Re: Footing Evaluation (*Revision to Original Letter dated October 4, 2024*)
57 Wesley Circle
Fuquay-Varina, NC

A representative of Giles Flythe Engineers was on site on October 3, 2024 to perform on-site open footing inspections of the previously excavated continuous wall/spot footings for the new construction single-family home/detached garage at the subject address. The footings are based on the structural plan drawings produced by Giles Flythe Engineers dated May 15, 2024.

DETACHED GARAGE FOOTING/FOUNDATION PLAN
SCALE: 1/4" = 1'-0"

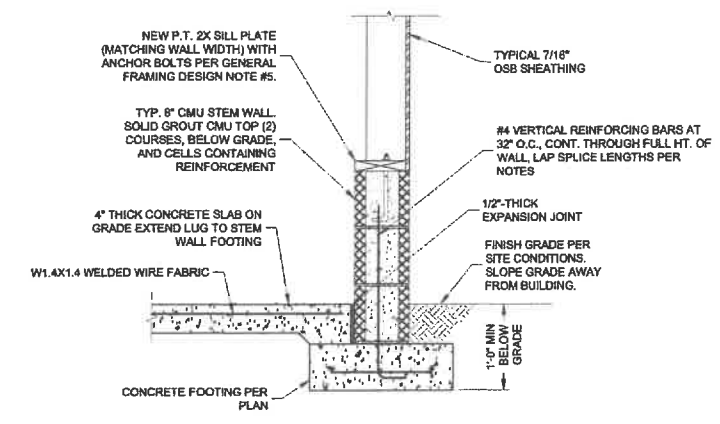
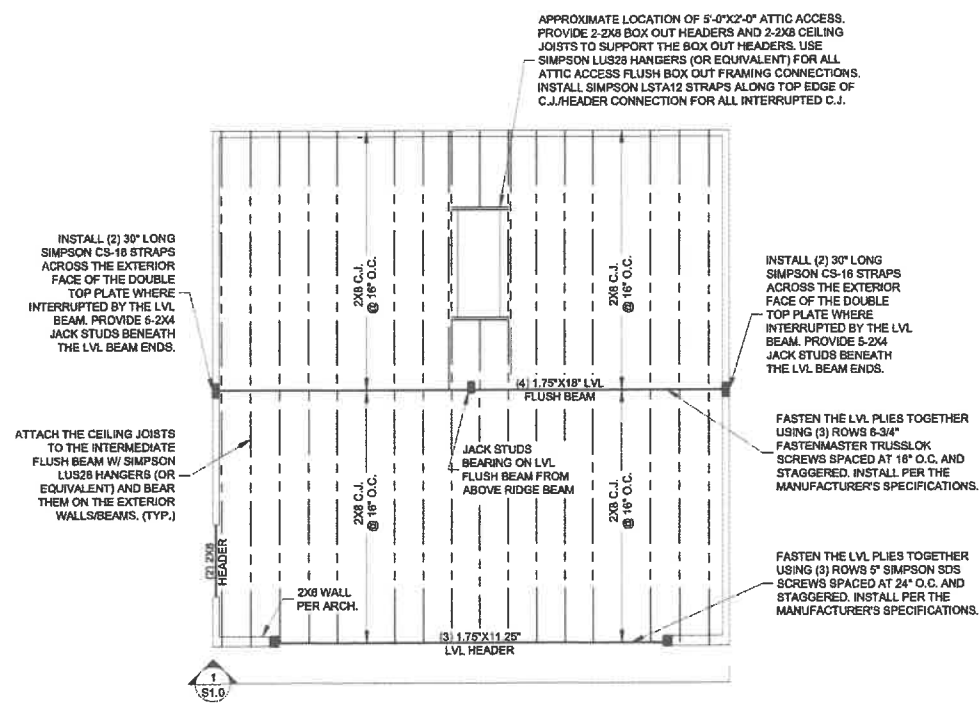
The wall footings for both the new single-family home as well as the detached garage structure had been excavated approximately 24" wide and approximately 24" deep. The spot footings for the interior masonry piers at the single-family home and along the perimeter of the detached garage had been excavated a minimum 24"x24" and approximately 24" deep. Spot footings for the new deck posts at the single-family home had been excavated a minimum 18"x18" and 12" deep. Overburden material was present along the sides of the footings.

Standing water was present within the evaluated footing areas throughout the entirety of the project site. Furthermore, deleterious soil materials (i.e., saturated soils and mud) were present in the footing areas at multiple locations. The exposed footing subgrades were evaluated using a T-handle 1/2" probe rod and performing hand auger borings with Dynamic Cone Penetrometer (DCP) testing at select intervals. The soil subgrades subjected to DCP testing within the footing areas of the single-family home exhibited penetration resistance values on the order of 15+ blows per increment (BPI). The soil subgrades subjected to DCP testing within the footing areas of the detached garage exhibited penetration resistance values on the order of 7 to 9 blows per increment (BPI) or more. We have provided recommendations below to address the condition of the footings.

- We recommend over-excavating **the entirety** of the footing areas for the new construction single-family home and detached garage (all wall and spot footing areas) an additional, minimum 12” below current subgrade due to evident, elevated groundwater levels and loose/muddy soils due to prolonged water saturation.
- Upon completion of the recommended over-excavated, the over-excavated footings shall be immediately backfilled with washed No. 57 stone to plan bearing grade. Stone is to be tamped and leveled out (not vibrated) in 6”-8” lifts. Note, bottom of concrete footings to be a minimum of 12” below grade.
- Prior to stone placement and concrete placement, contractor shall ensure all footing areas are dewatered and all mud/loose material are removed.
